# **APPENDIX 2**

## **Summary of Responses to** **Agency Submissions**

**SUMMARY OF AGENCY SUBMISSIONS**

| DWG No | ODA070 F          |

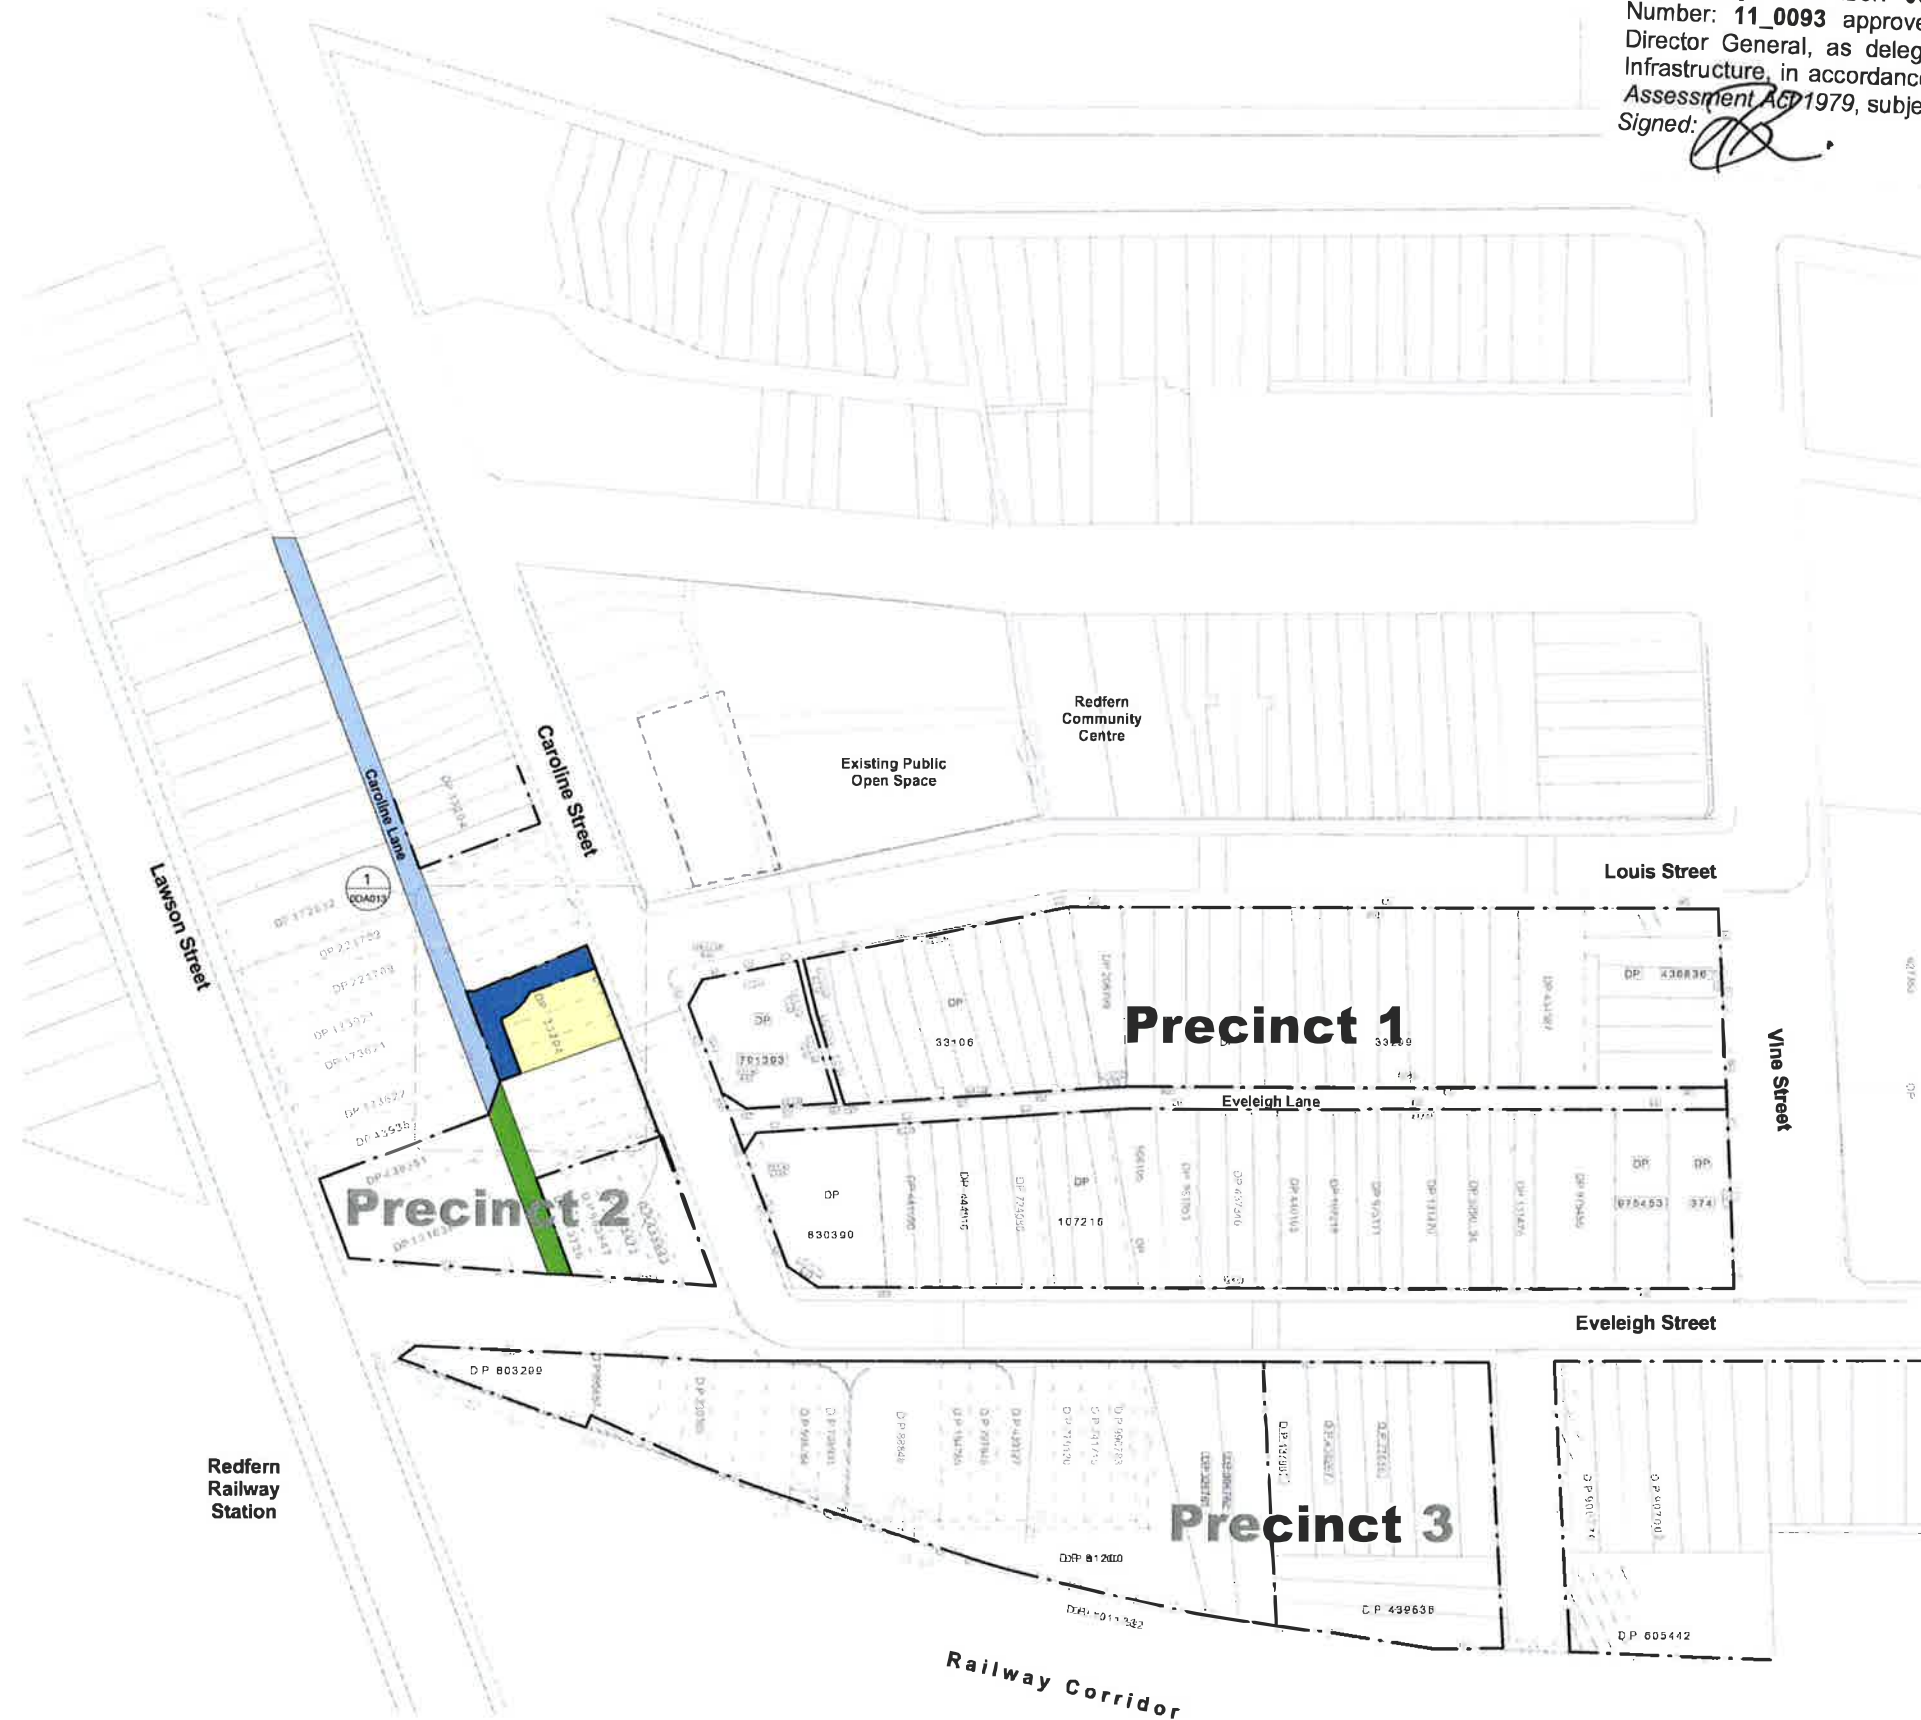
| Authority/Organisation Submissions |                                    |   |   |
|------------------------------------|------------------------------------|---|---|
|                                    |                                    | Council should be consulted to agree on finishes and furnishing of the public domain prior to the issue of a Construction Certificate   | This issue can be addressed by appropriate conditions of approval. Public Domain of 700m <sup>2</sup> noted as areas A, B & C refer to plan <b>ODA070[F]</b> .  |

| DWG No. | 1DA091 E          |

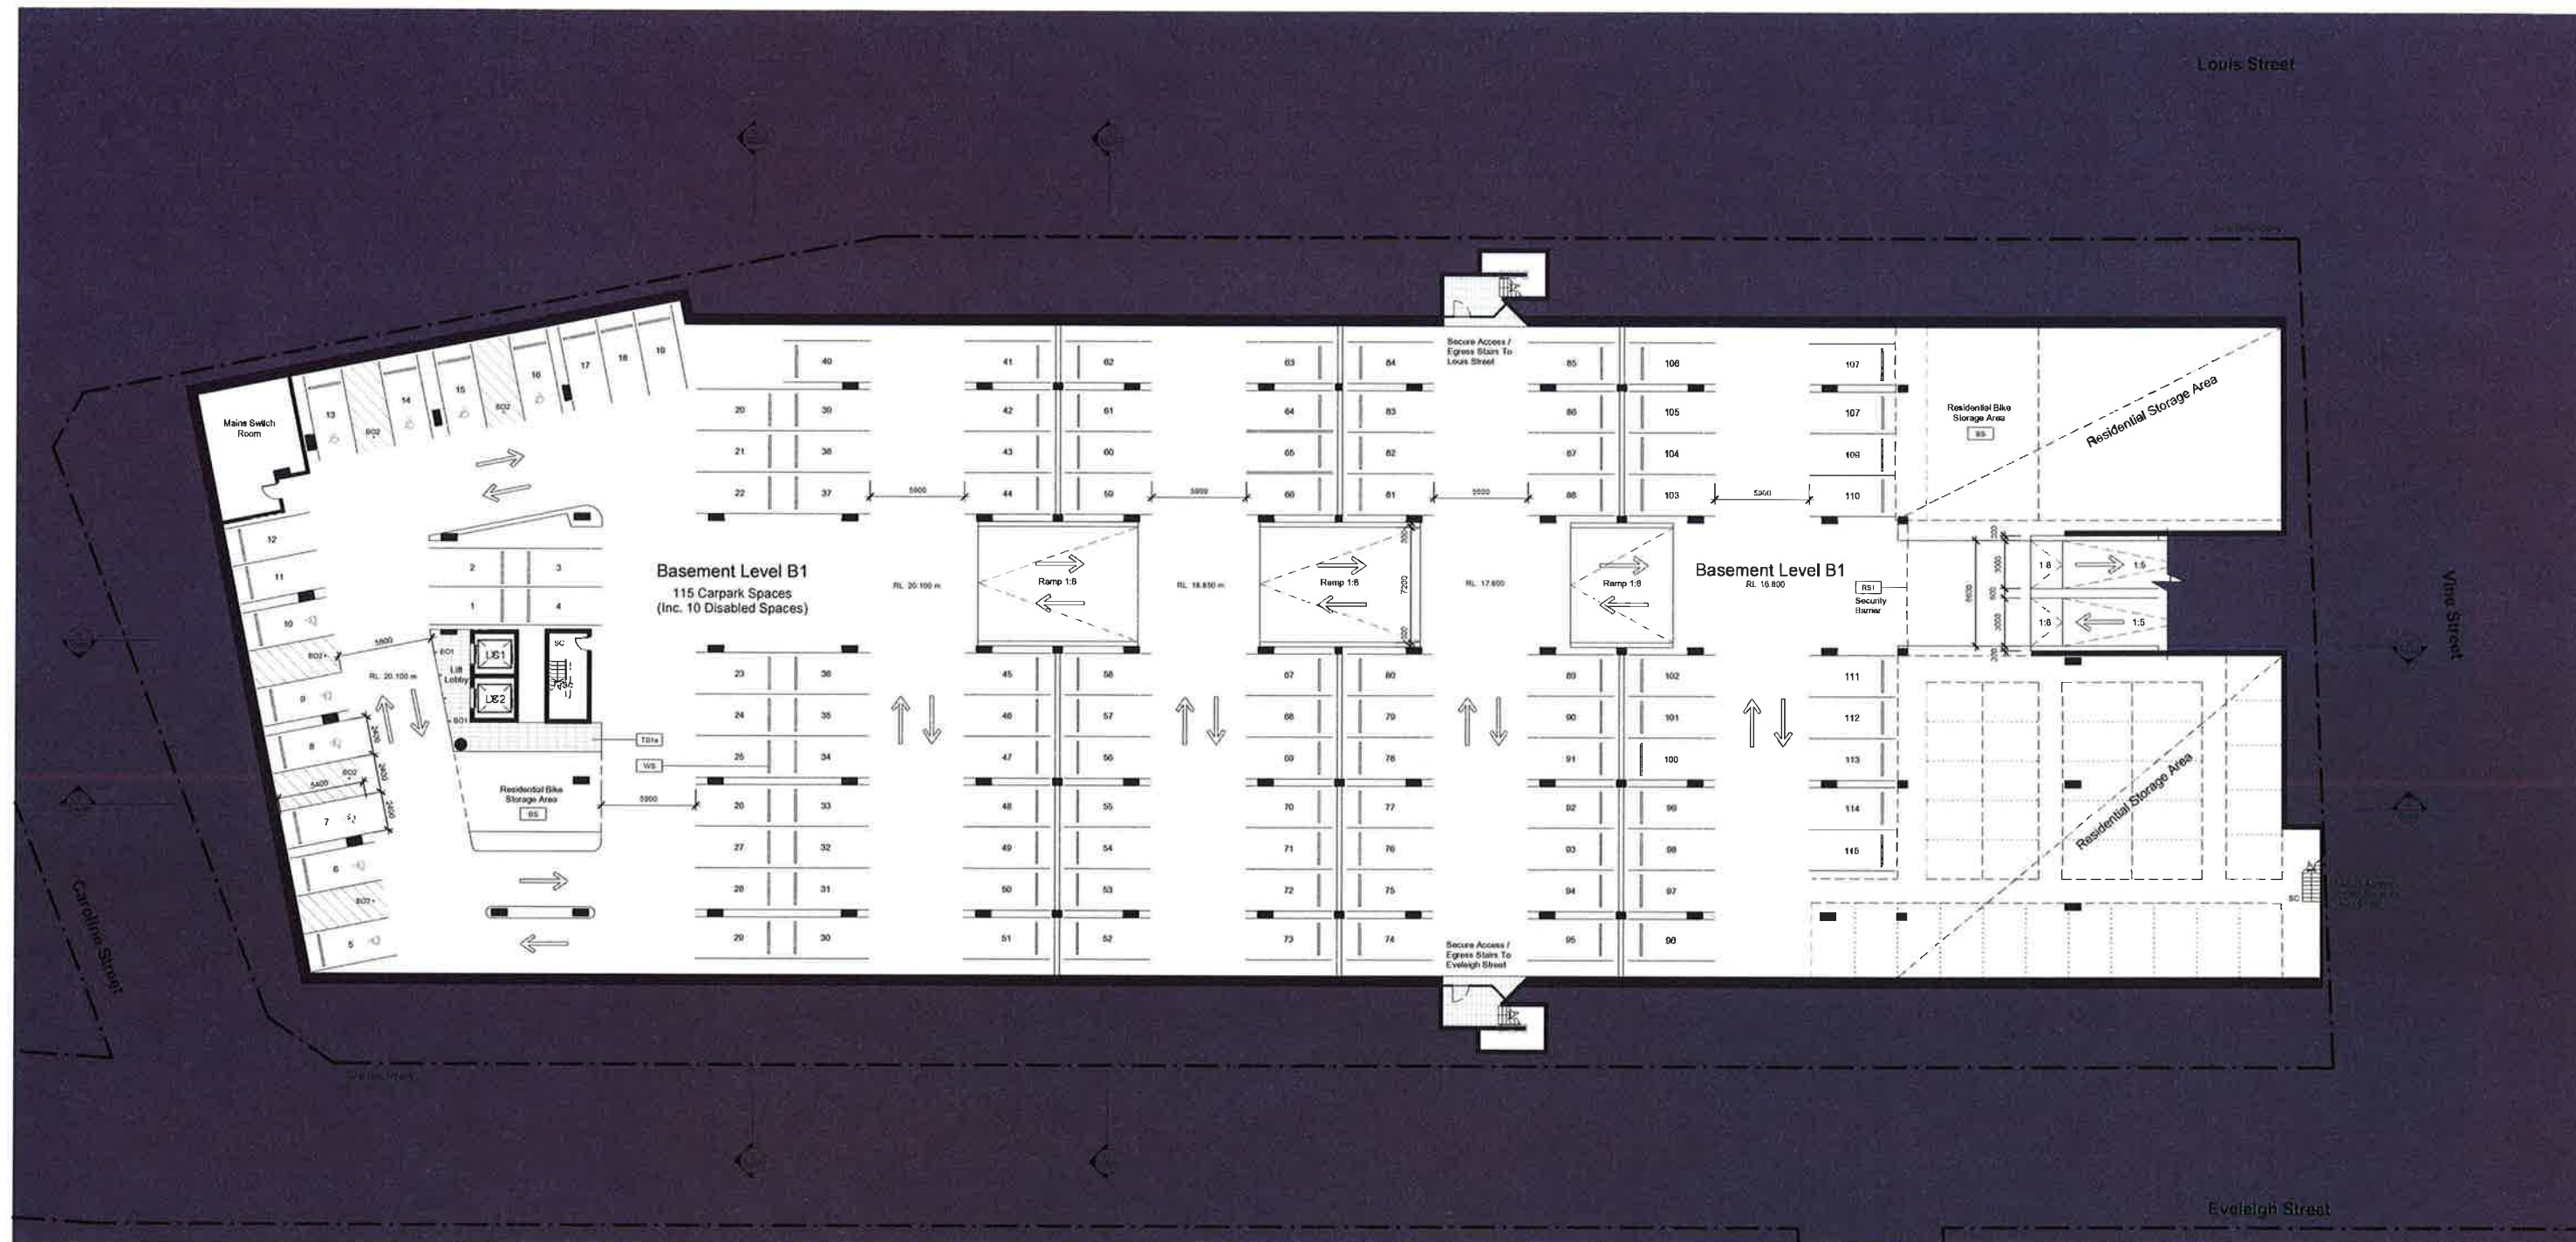
| Authority/Organisation Submissions |                              |   |   |
|------------------------------------|------------------------------|---|---|
|                                    |                              | There is insufficient evidence of bike racks in the development   | Student bike racks noted on Plan <b>1DA100[E]</b> .   |

1DA101 E

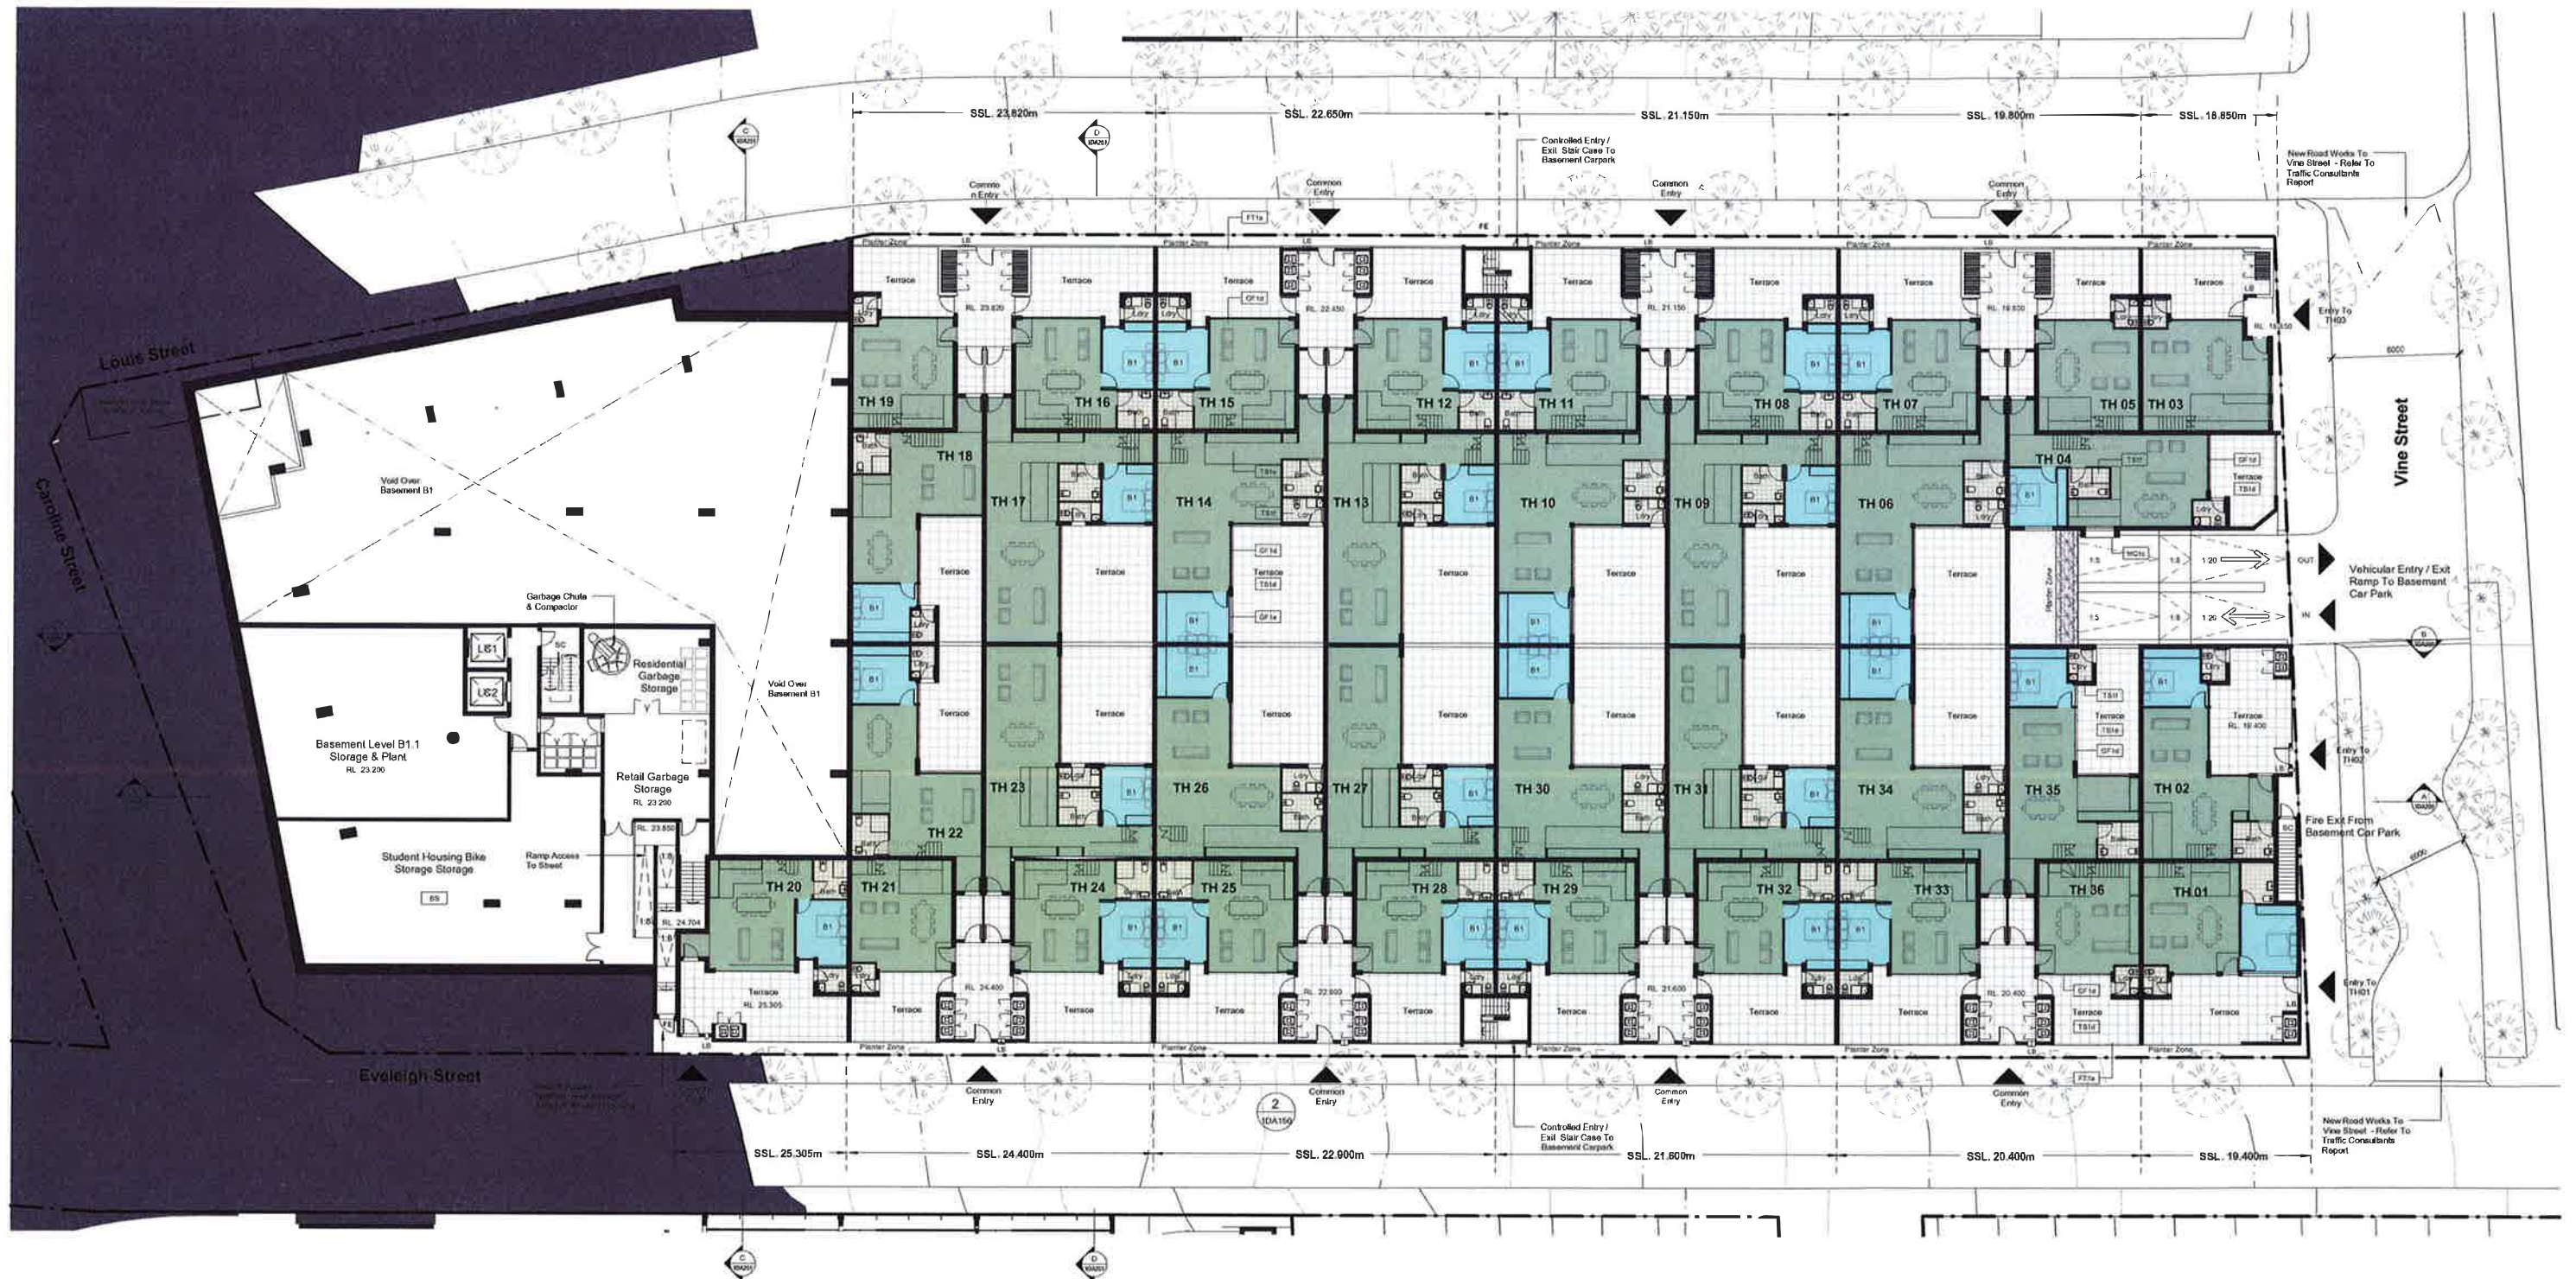
| Authority/Organisation Submissions |                              |   |   |
|------------------------------------|------------------------------|---|---|
|                                    |                              | Car parking should be provided close to the child care centre for children to be dropped-off and picked-up  | The plans have been amended to provide 8 on-street car parking spaces on the northern side of Caroline Street opposite the centre. It is proposed that a 15 minute time limit should be applied to these spaces between the hours of 6.30am and 9.00am and between 3.00pm and 7.00pm on weekdays and a 2-hour limit be imposed at other times noted on plan <b>1DA101[E]</b> .                                      |
